Recommendation Report for Planning Permission for Works or Extension to a Dwelling

REF NO: A/99/14/HH

LOCATION: 2 Woodford Villas
High Street
Angmering

PROPOSAL: Removal and reconstruction of part of the front boundary wall (resubmission following A/46/14/HH). This application affects the character and appearance of the Angmering Conservation Area.

DRAWING TITLE
PROPOSED FRONT BOUNDARY WALL
ELEVATIONS, PLAN AND SECTION

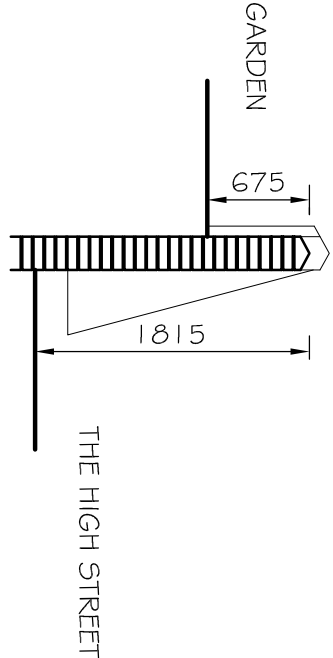
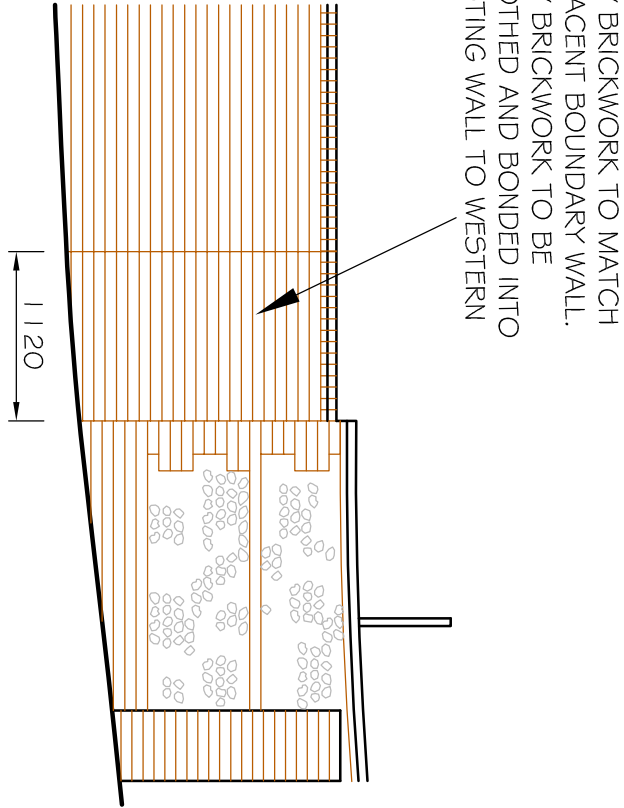
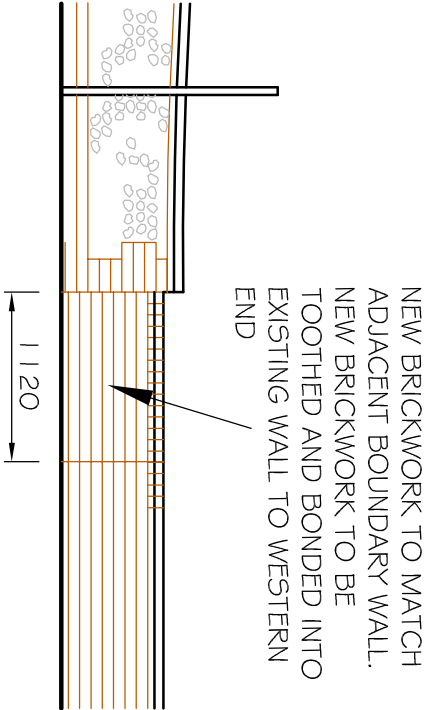
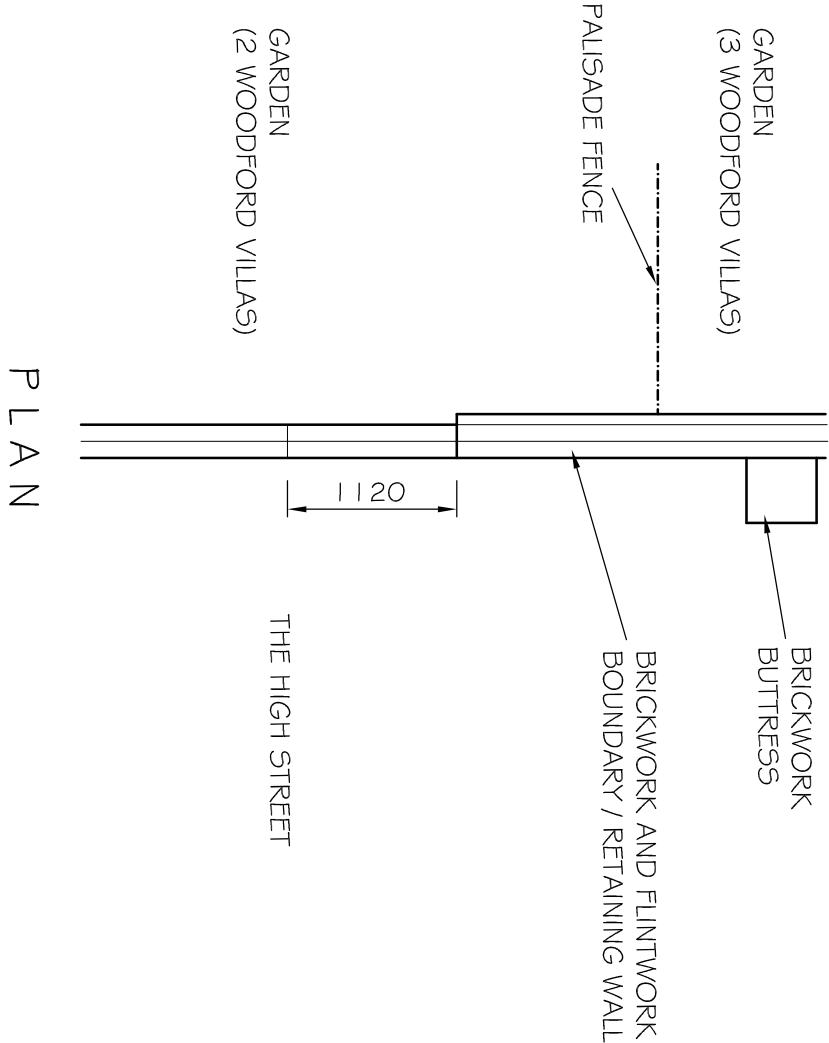
It is considered unfortunate for the opening to be permanently in-filled. An alternative, more acceptable approach could be to close the opening with a gate or similar means of enclosure to enable the views through to the space beyond to remain. It is not clear if any research has been undertaken as to the wall and its associations with the properties and the local area. For instance, was it a historic access point, or added much later to provide easy access for the residents. Further clarification should be sought so that a full assessment of the impact of the works can be undertaken (this is not part of the submitted application). The loss of the access point will be problematic if it can be proven to have associations with the residential development behind it.

This application is for the removal and reconstruction of a section of front boundary brick walling. The wall has also been the subject of previous planning application A/46/14/HH which sought the retention of the existing section but was found to be unacceptable in design terms and so the application was Refused. This application considers a replacement section comprising of new brickwork to the same height as the existing walling on either side and which will be toothed and bonded at the western end for better integration. The decorative cockerel that sits on the wall is to be omitted in this scheme compared to A/46/14/HH.

The Conservation Officer has concerns with the proposal considering it to be unfortunate for the opening to be permanently in-filled. It is also not clear if any research has been undertaken as to the wall and its associations with the properties and the local area including whether it was a historic access point. It is considered that a full assessment of the impact of the works should have been undertaken and has not formed part of the submitted application. It is further

considered that the loss of the access point will be problematic if it can be proven to have associations with the residential development behind it.

It is therefore considered that the proposed replacement section of walling is unacceptable in design terms and neither preserves nor enhances the character and appearance of the Conservation Area. It therefore conflicts with policies GEN7(ii) and AREA2 of the Arun District Local Plan.

- 1 The proposed replacement front boundary wall section by reason of it in-filling a previous access point would cause unacceptable harm to the visual amenities of the site and neither preserves nor enhances the character and appearance of the Conservation Area and in the absence of insufficient information submitted with the application regarding the wall and its associations with Woodford Villas and the local area including whether it was a historic access point has not been sufficiently justified which is in conflict with policies GEN7 and AREA2 of the Arun District Local Plan and policies D DM1 and HER DM3 of the Emerging Local Plan and the National Planning Policy Framework.
- 2 **INFORMATIVE:** Statement pursuant to Article 31 of the Town and Country Planning (Development Management Procedure)(England) (Amendment No. 2) Order 2012. The
